Application for A Non-material Amendment Following a Grant of Planning Permission

Development Application for a non-material amendment following a grant of planning permission M/25/11/ to add weatherboarding above first floor level to gables in lieu of painted pebbledash and widen rear patio doors.

Location Yellow Hammers 24 Sea Lane Middleton on Sea

PROPOSED ROOF PLAN SCALE 1:100

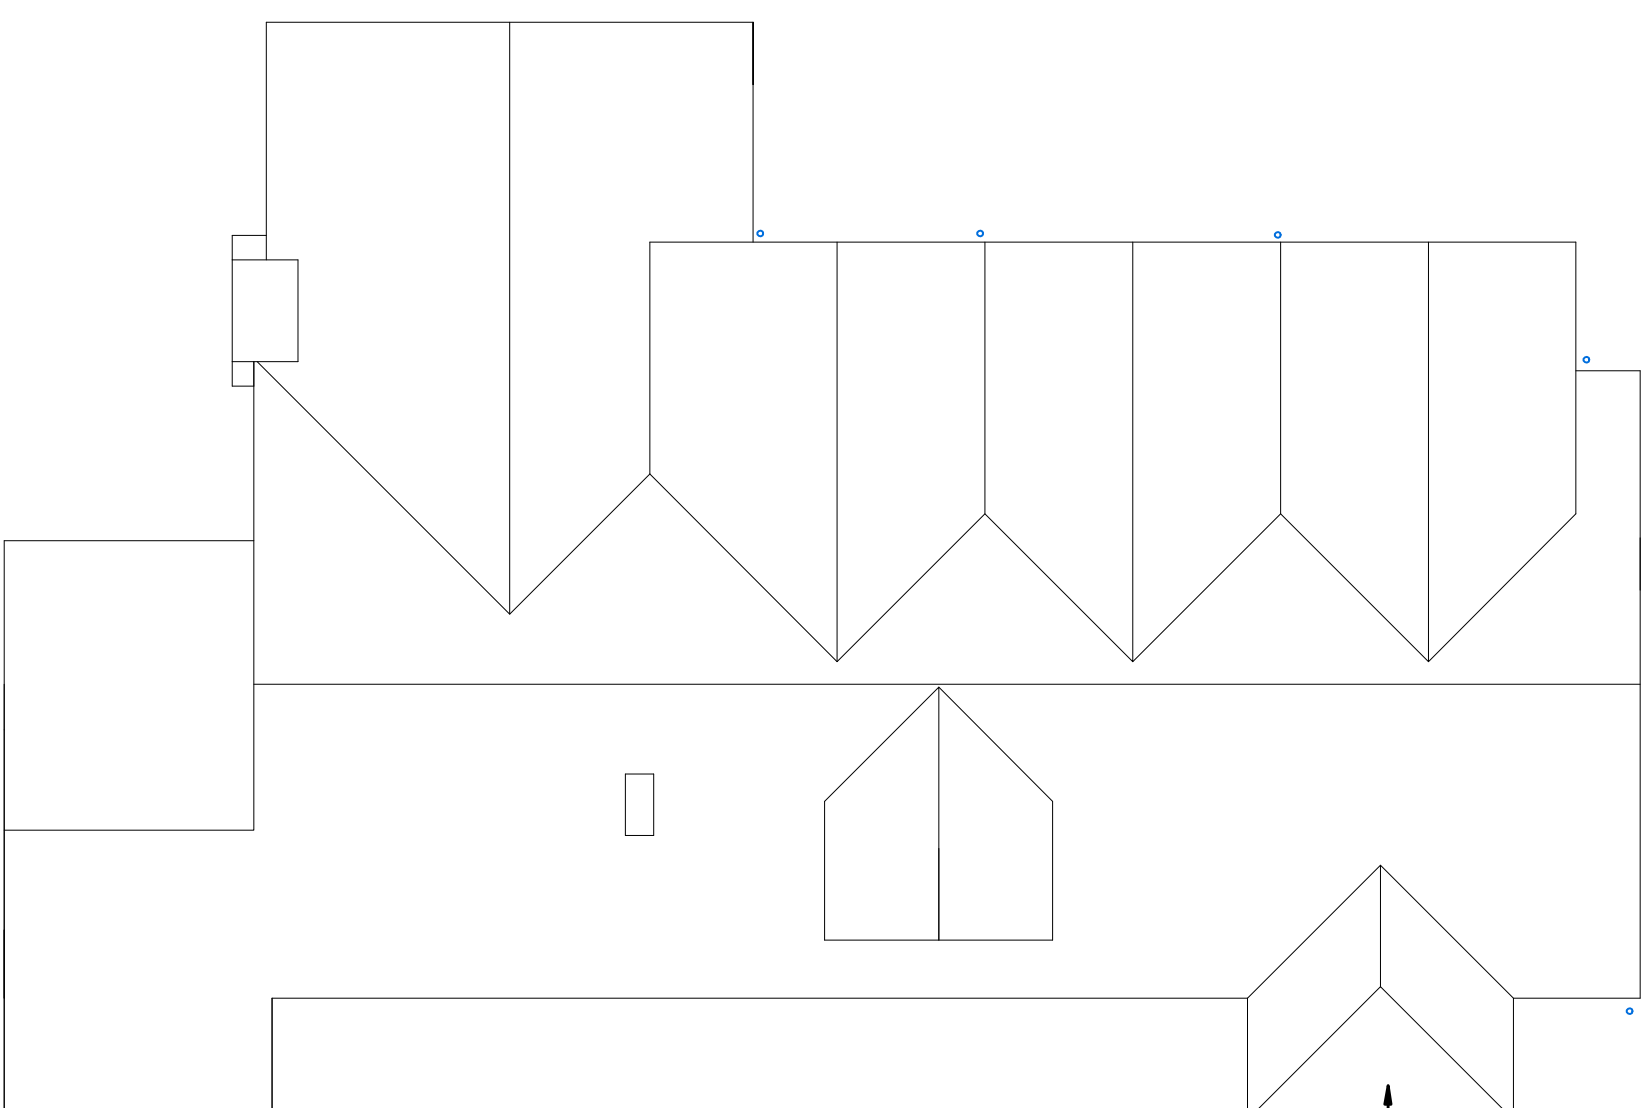
As discussed on the telephone on 12/02/2013, please submit a revised plan not showing the velux window that was not on the original drawings on application M/25/11/.
